Five Ways, Crows Nest (SSD-66826207) | Traffic Addendum Statement

This traffic addendum statement has been prepared by JMT Consulting to respond to the feedback provided by Transport for NSW (TfNSW) following the exhibition of State Significant Development SSD-66826207 for the proposed development at Five Ways, Crows Nest. This document specifically responds to Item 5 (Traffic Impact) of the TfNSW correspondence dated 4 June 2024 (refer Appendix A of this document). This addendum statement should be read in conjunction with the updated transport impact assessment report prepared by JMT Consulting and dated 29 August 2024 submitted as part of the broader Response to Submissions package.

**MIXED USE DEVELOPMENT INCLUDING IN-FILL AFFORDABLE HOUSING - FIVE WAYS, CROWS NEST
EXHIBITION OF EIS**

Figure 2 Proposed vehicle site access

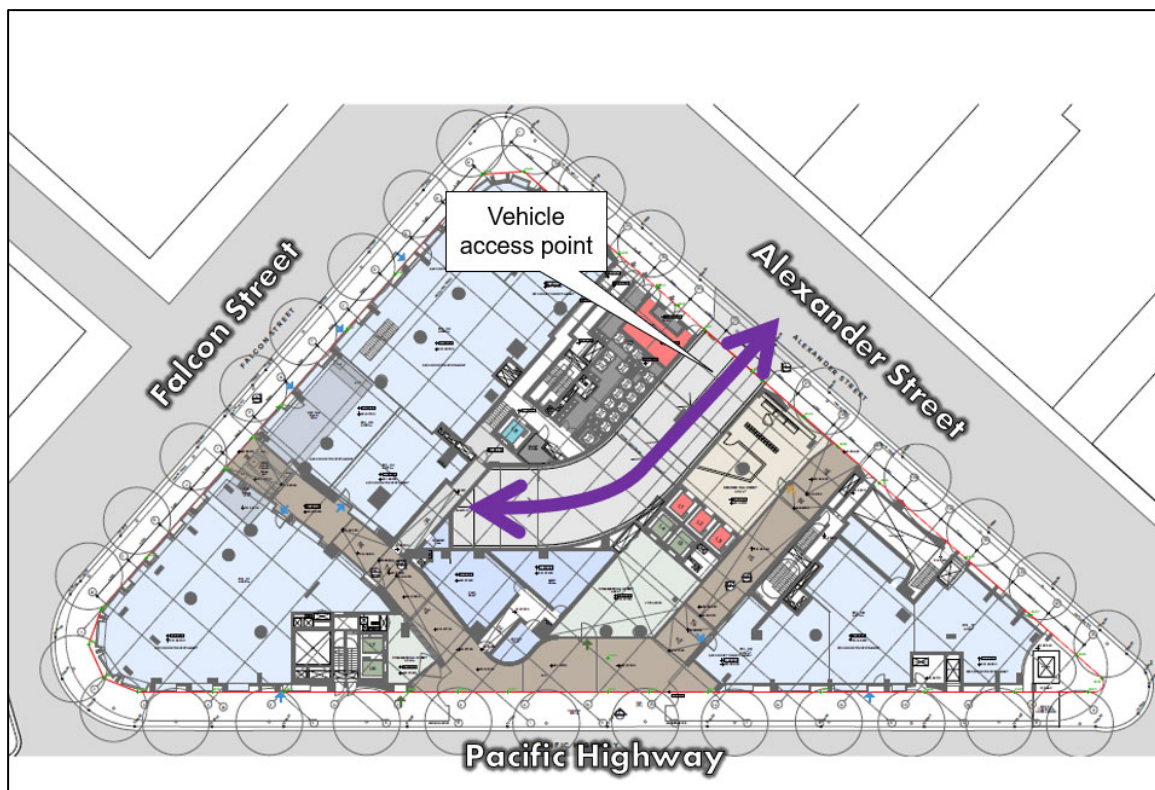
b) The proposed development site driveway was modelled as an isolated intersection using Sidra Intersection 9.1. Due to the closely spaced intersections and platoons created by those intersections and the queuing that is typically observed northbound on Alexander Street adjacent to the proposed development, additional information is required in relation to the existing northbound queues and how often they are observed to extend past the proposed development driveway during weekday and weekend peak periods.

c) Motorists turning right into the proposed site access on Alexander Street have the potential to cause queueing on Alexander Street which could extend back to the signalised intersection of Falcon Street / Alexander Street, impacting signal operations. Consideration may need to be given to the removal of some on-street parking in the kerbside lane on Alexander Street (southbound) in peak periods to allow space for vehicles to pass vehicles turning right into the site. North Sydney Council should be consulted in this regard.

In response to concerns raised by TfNSW regarding the traffic impact of the proposal, the design of the driveway has been modified to restrict vehicle movements out of the driveway on Alexander Street to left in – left out only. This turning restriction will remove any impact of queueing vehicles on Alexander Street waiting to turn right into the site and therefore completely eliminating any risk of traffic queuing back to the Falcon Street traffic lights.

In response to concerns raised by TfNSW regarding the traffic impact of the proposal, the design of the driveway has been modified to restrict vehicle movements out of the driveway on Alexander Street to left in – left out only. This turning restriction will remove any impact of queueing vehicles on Alexander Street waiting to turn right into the site and therefore completely eliminating any risk of traffic queuing back to the Falcon Street traffic lights.
